EPC STORMWATER REVIEW COMMENTS IN ORANGE BOXES WITH BLACK TEXT

The Shire At Old Ranch
 Howells & Old Ranch Road
 Colorado Springs, CO

GENERAL SITE PLAN & PROJECT DATA

File Number: PPR2410

SP
1

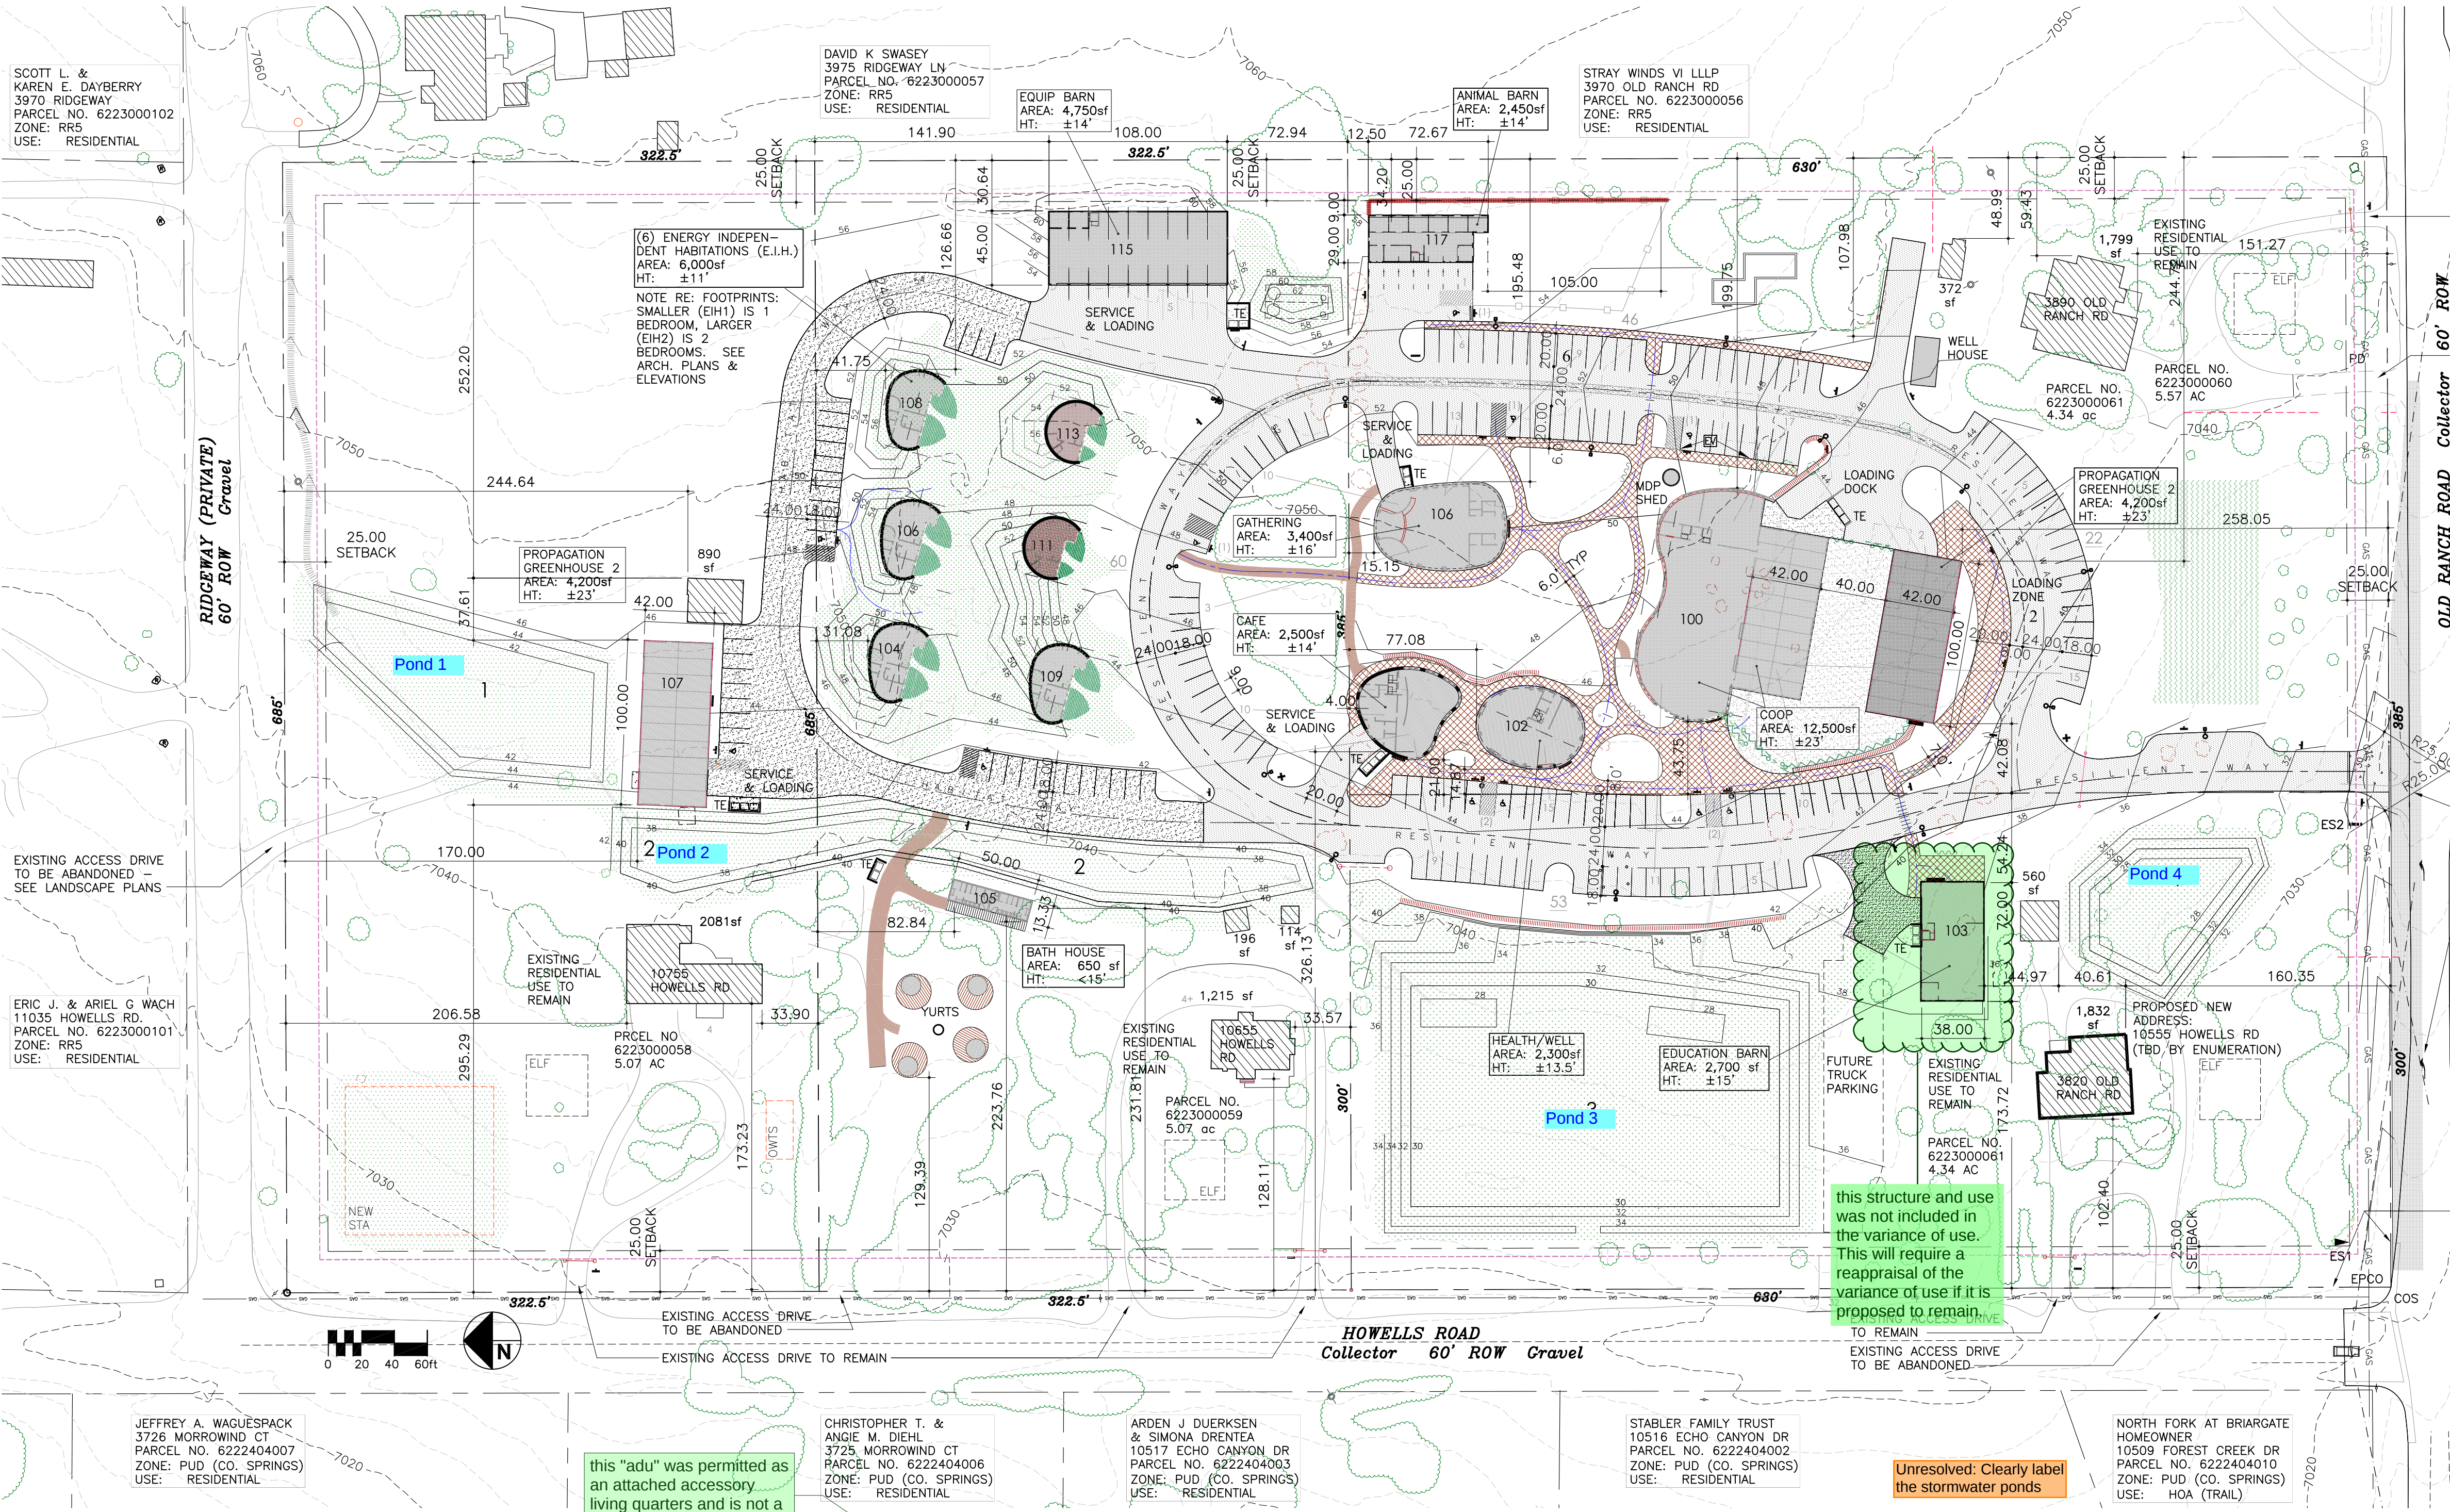
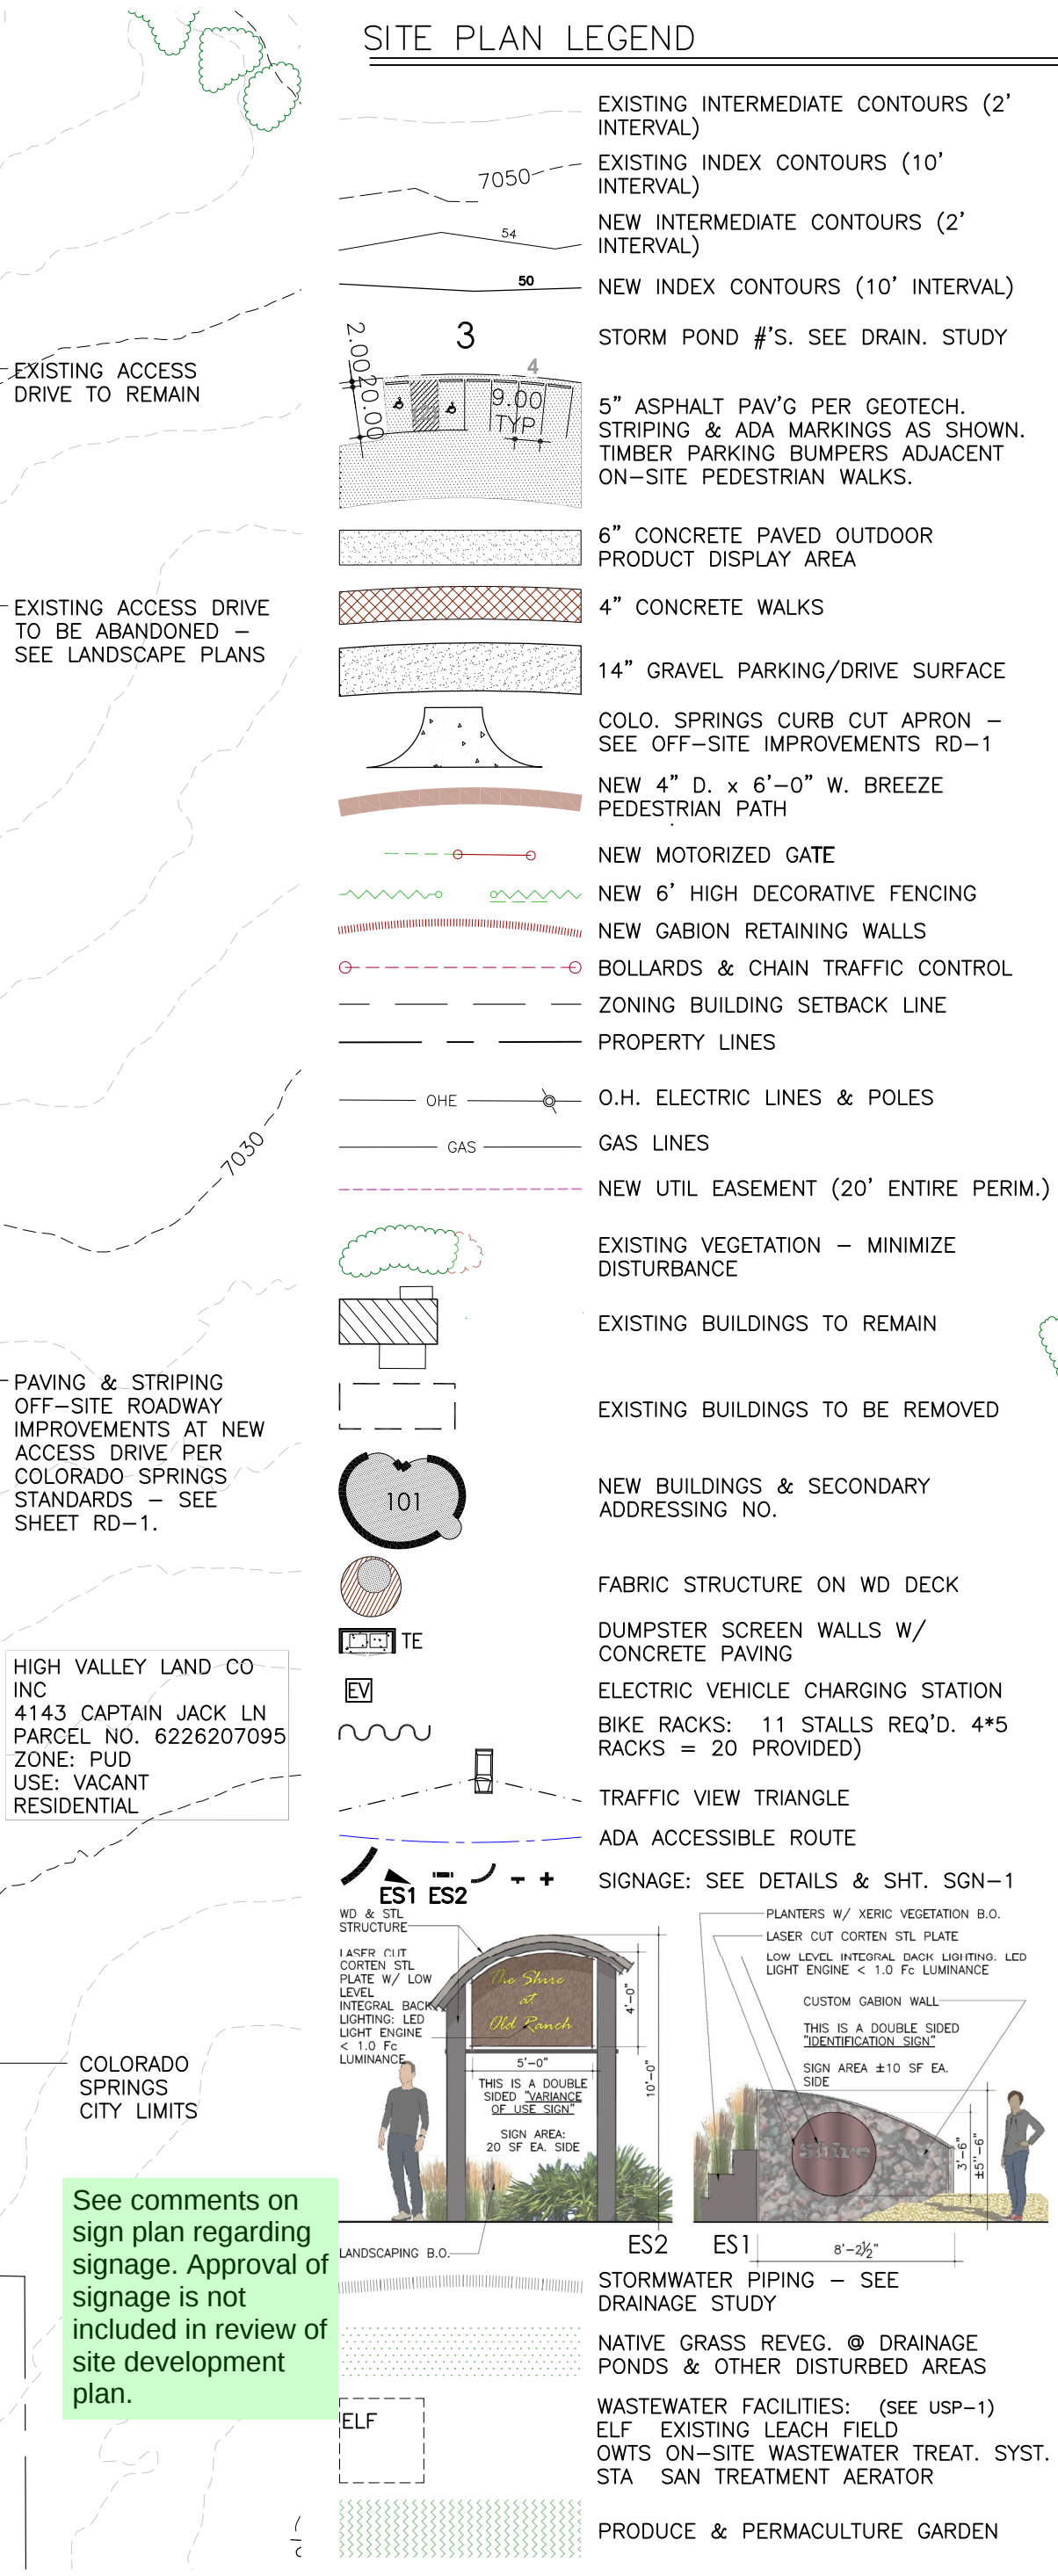
Recommend turning off or turning down the contours on this drawing for clarity of the map. Contours are shown on the GEC plan

Please provide setbacks distances to property line

Please include traffic ingress and egress on the property

Please clarify/label whether these existing access points are proposed to remain or will be removed. Coordinate with the City of Colorado Springs as they control access off Old Ranch Rd

Please depict sidewalks and their width

Provide ROW dimensions

Provide setbacks distances

Provide ROW dimensions

Please provide setbacks distances to property lines

These are VERY similar, please revise

Provide sq footage of buildings, height, and setbacks to property lines

Please separate and clarify which is which

Contact the City of Colorado Springs for access to Old Ranch Rd. Old Ranch Rd is not County maintained

Please provide dimensions and setbacks to property lines

please label all the proposed stormwater ponds

Show surface type of roadways

Why are these different? They should be the same this plan is to show in detail what was approved at the variance of use stage

Please provide one scale

Provide ROW dimensions

Please include:
 -Open space, landscaping, and impermeable surface percentage
 -The layout and location of all off-street parking, loading and other vehicular use areas

USP-1  
 Utilities Service Plan  
 & Details

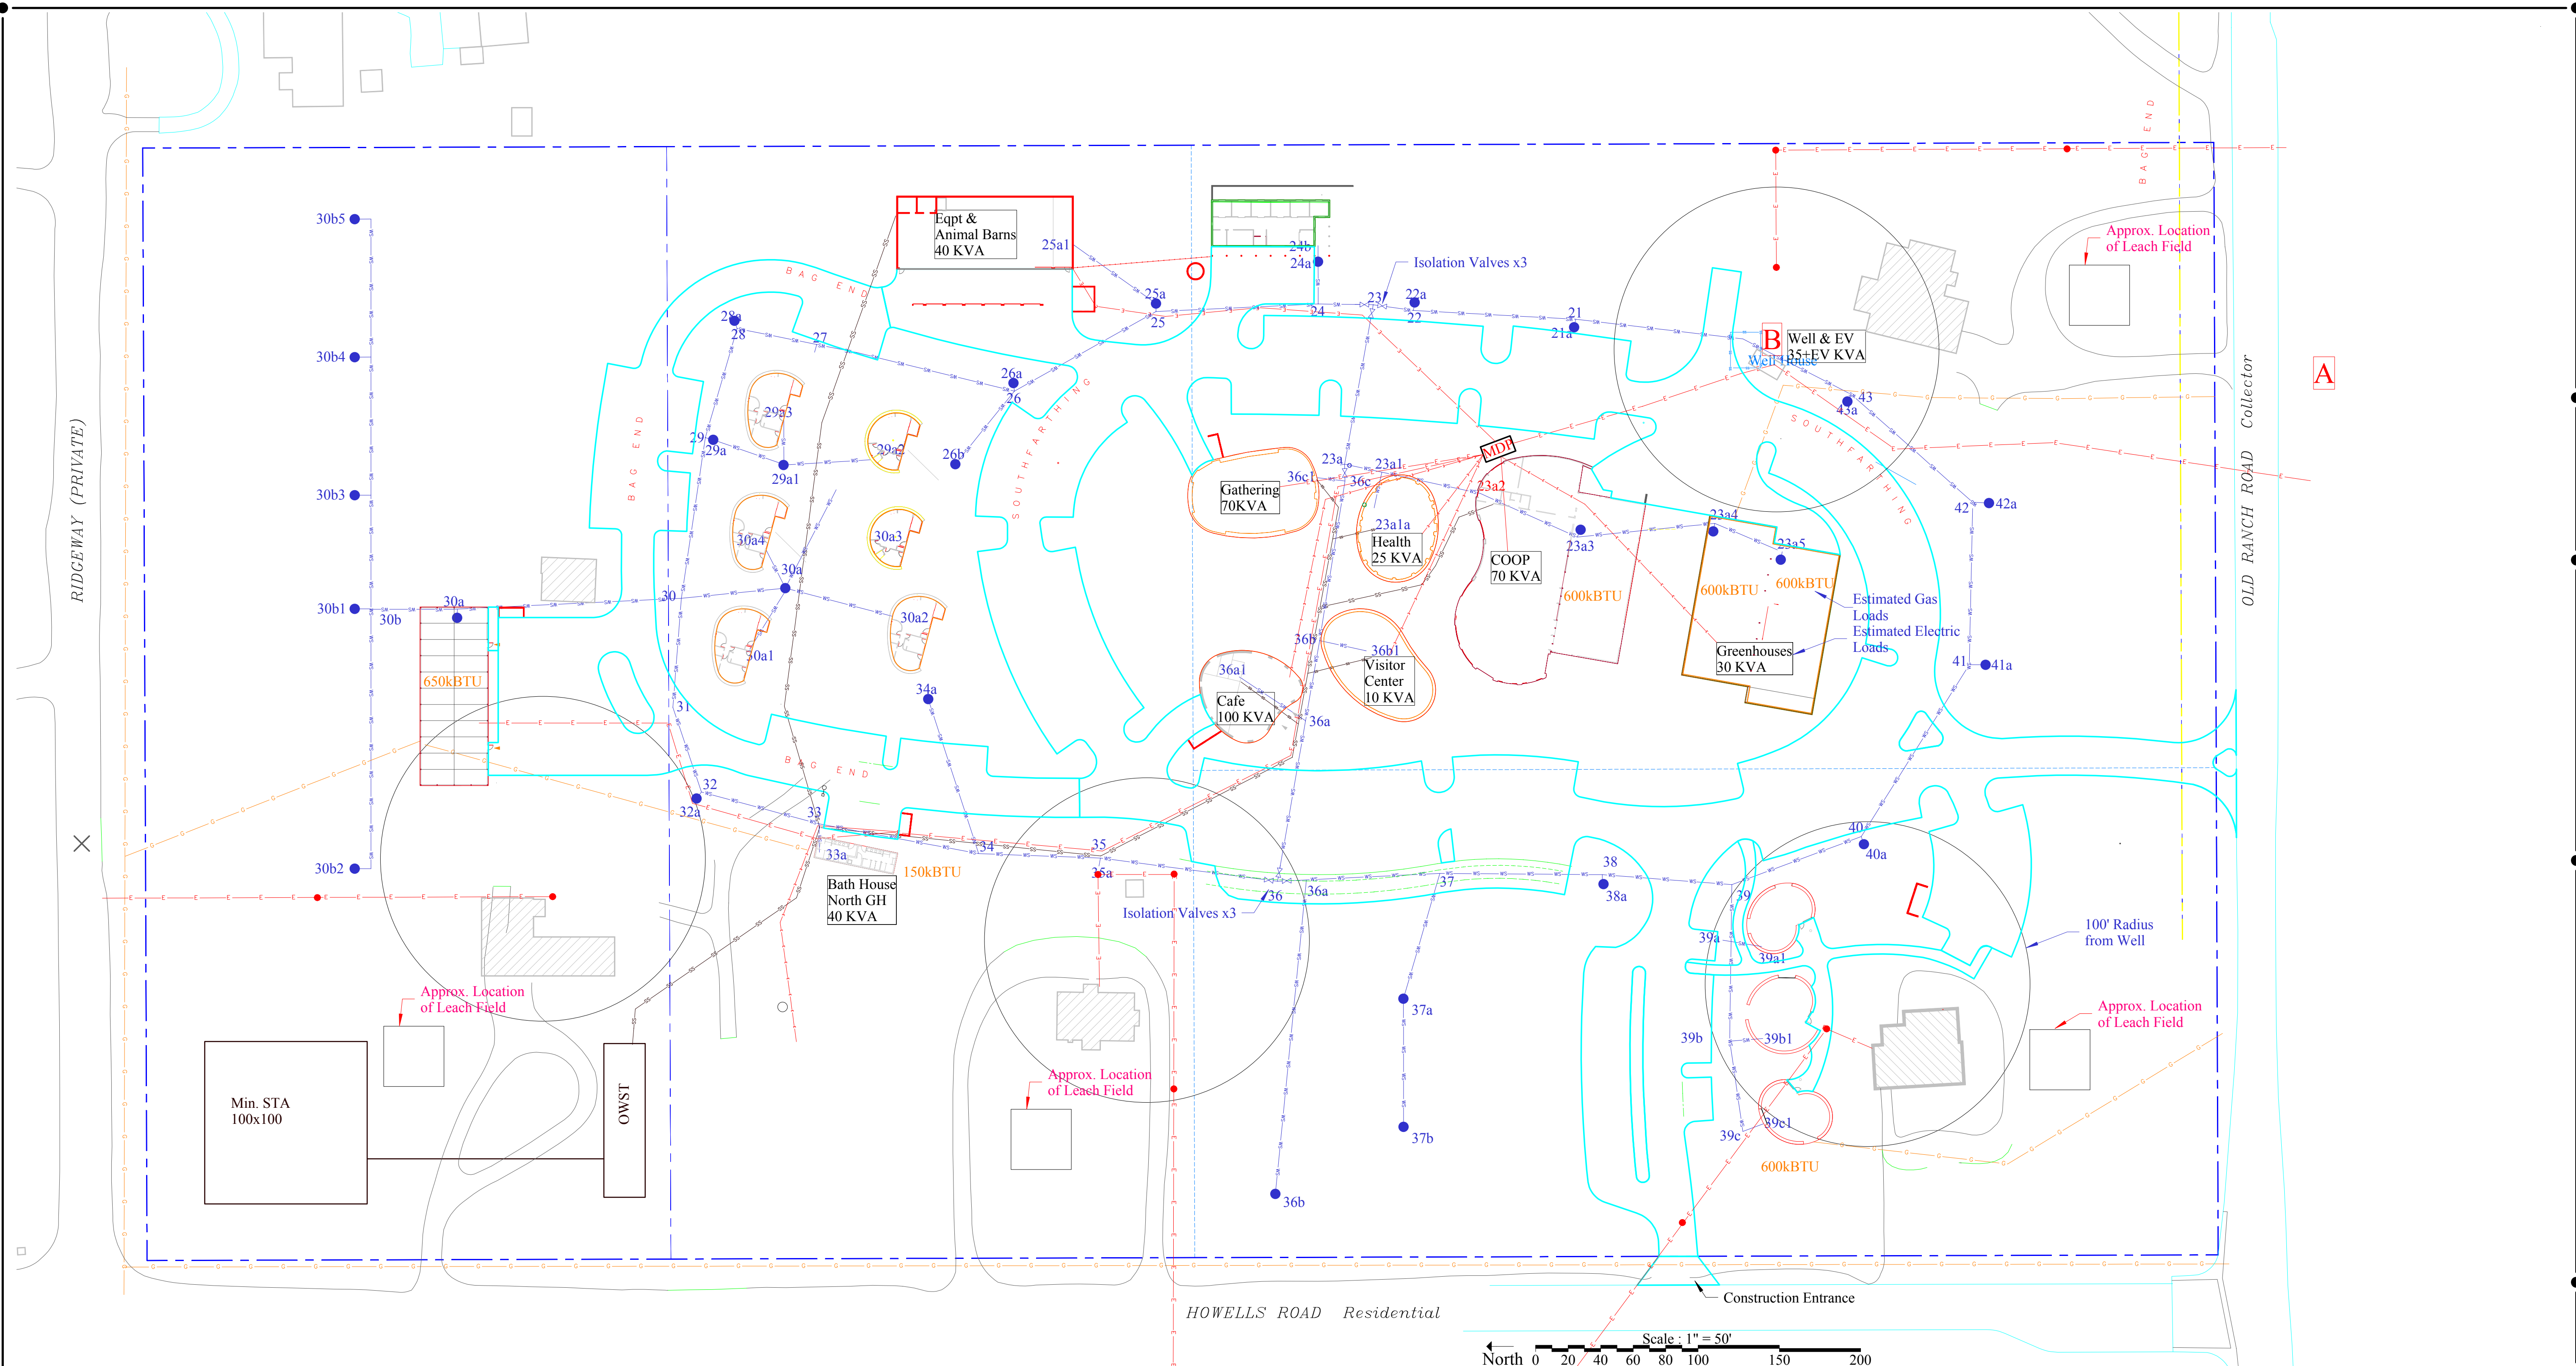
Verify location, may be too close to proposed ponds. For separation requirements from septic systems and permanent water quality facilities, see ECM section 1.7.6 and Colorado's Rules and Regulations for Water Well Construction, Pump Installation, and Monitoring and Observation Hole/Well Construction.
